Recommendation: Refuse

Proposal: Two storey front and rear extensions with single storey infill and formation of new first floor extension over side area of dwelling.
Enlargement of vehicle access width in frontage stone boundary wall

front north elevation

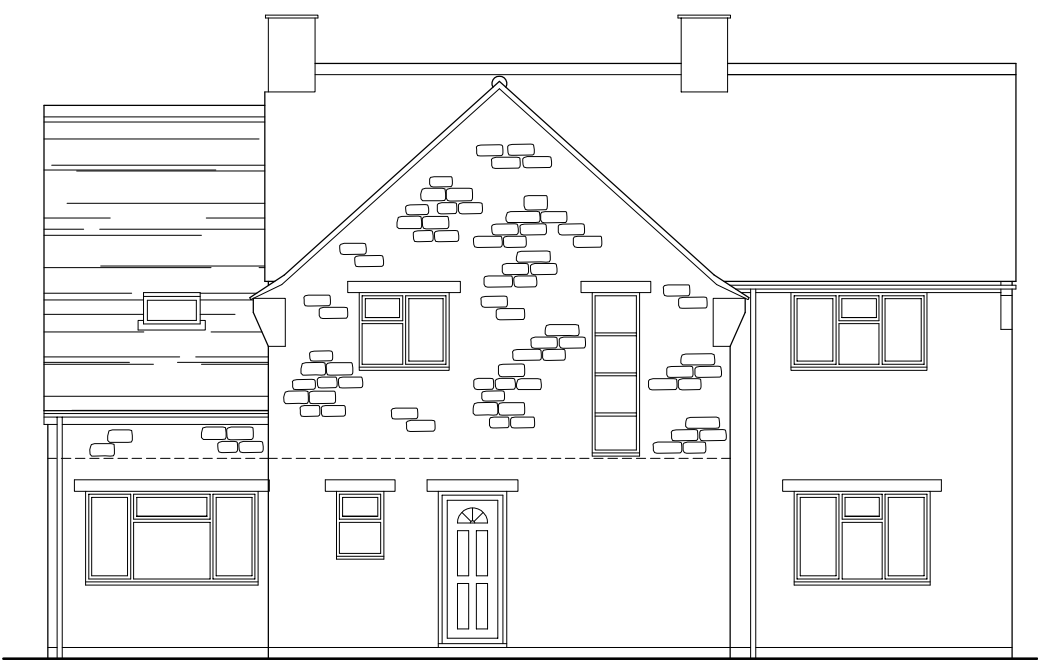
- 8.5. The introduction of a front gable extension, which does not show subservience to the main dwelling, and would detract from the simple linear character of the host dwelling is the type of development that the design guide seeks to guard against. The harm is exacerbated by the fact that the application property is within the setting of the Bodicote Conservation Area and would result in less than substantial harm to this heritage asset.

- 8.6. Whilst the side/rear extension would appear subservient to the original dwelling and is acceptable in principle the cat slide side which extends beyond the principal

elevation is an unfortunate feature which would further harm the simplicity of the host building's front elevation.

- 8.7. The rear extensions are of an acceptable design and would not be visible in the public realm and would therefore be considered acceptable in this regard.
- 8.8. The proposed front and side extensions are considered to cause harm the character and appearance of the area by virtue of their incongruous design causing harm to the street scene and less than substantial harm to the setting of the Bodicote Conservation Area. They this fail to accord with Government guidance contained within the NPPF, Policy ESD15 of the Cherwell Local Plan 2011-2031 Part 1 and saved Policies C28 and C30 of the Cherwell Local Plan 1996.

first floor plan

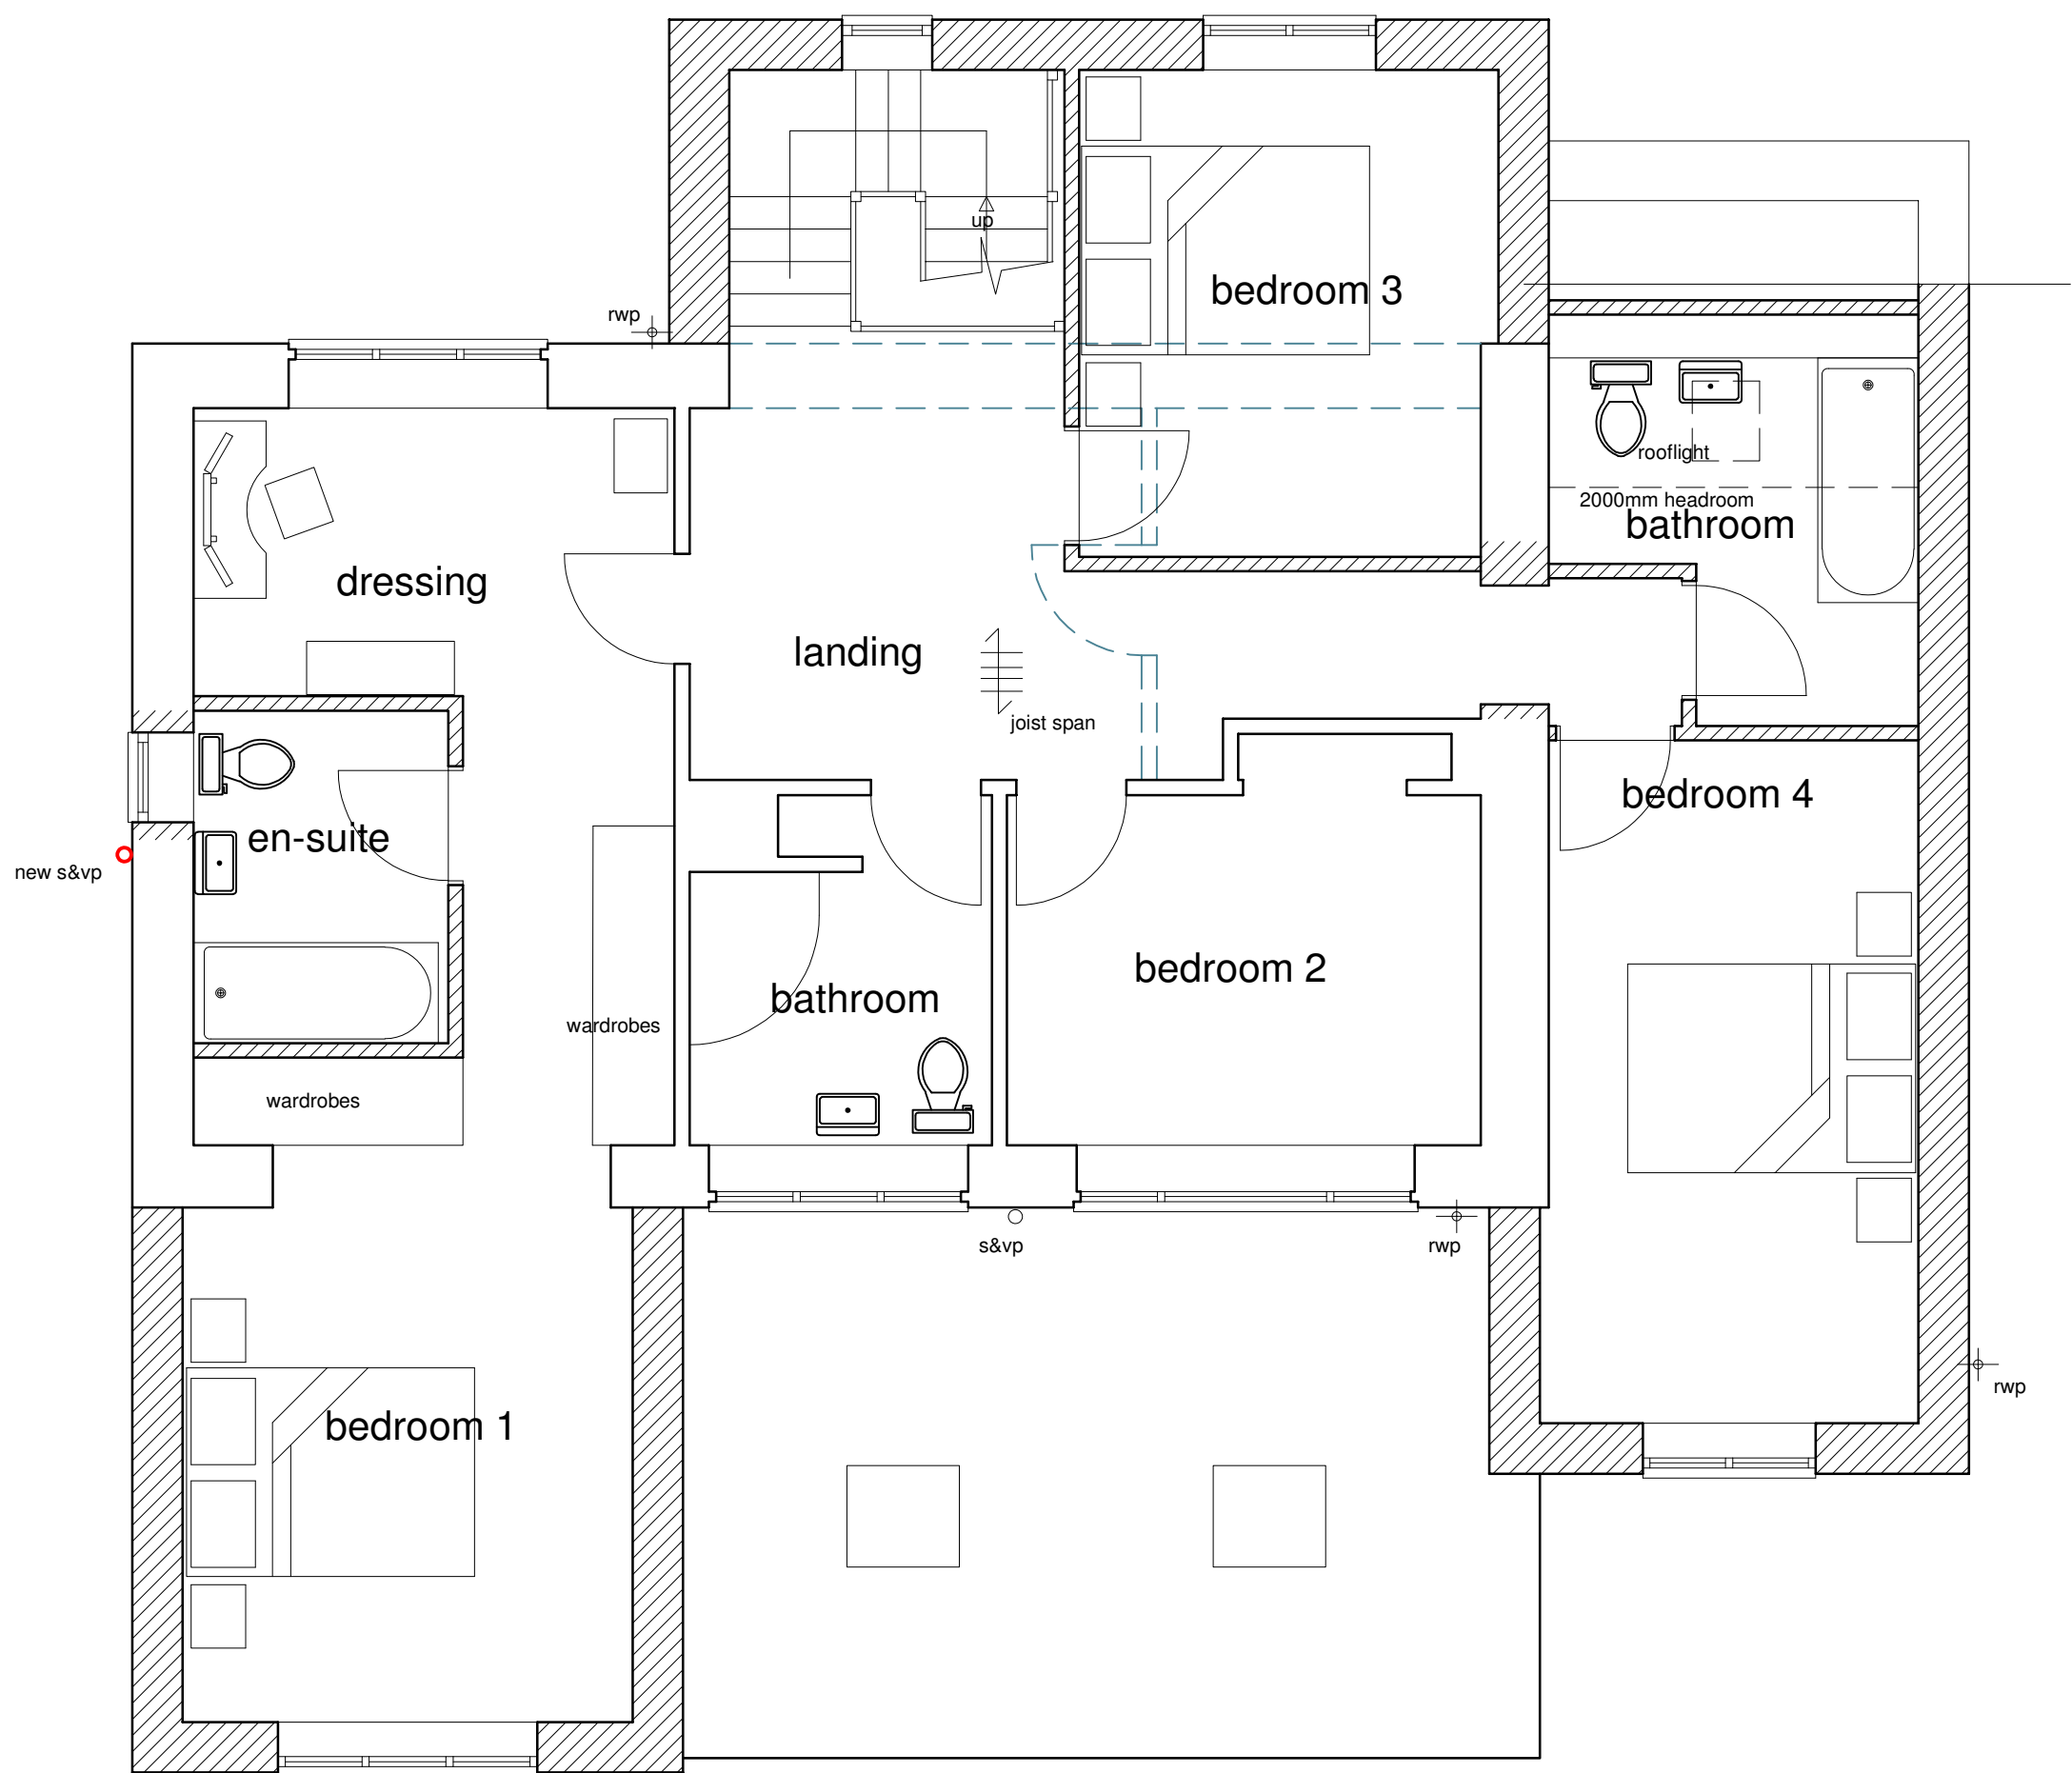
- 8.11. The proposed side/rear extension (i.e. bedroom 4 and bathroom at first floor level) would be set adjacent to the Old Thatch, which is set at right angles to the application property. This part of the proposal would have a significant impact on the residential amenity of the occupiers of this property by way of presenting an overbearing impact on this neighbour. Furthermore, the side extension would result in a reduction in light and outlook to this neighbour.

- 8.14. The proposed two-storey rear/side extension is considered to result in demonstrable harm to neighbour amenity as set out above. Thus, the proposals fail to accord with Government guidance contained within the NPPF, Policy ESD15 of the Cherwell Local Plan 2011-2031 Part 1 and saved Policy C30 of the Cherwell Local Plan 1996.
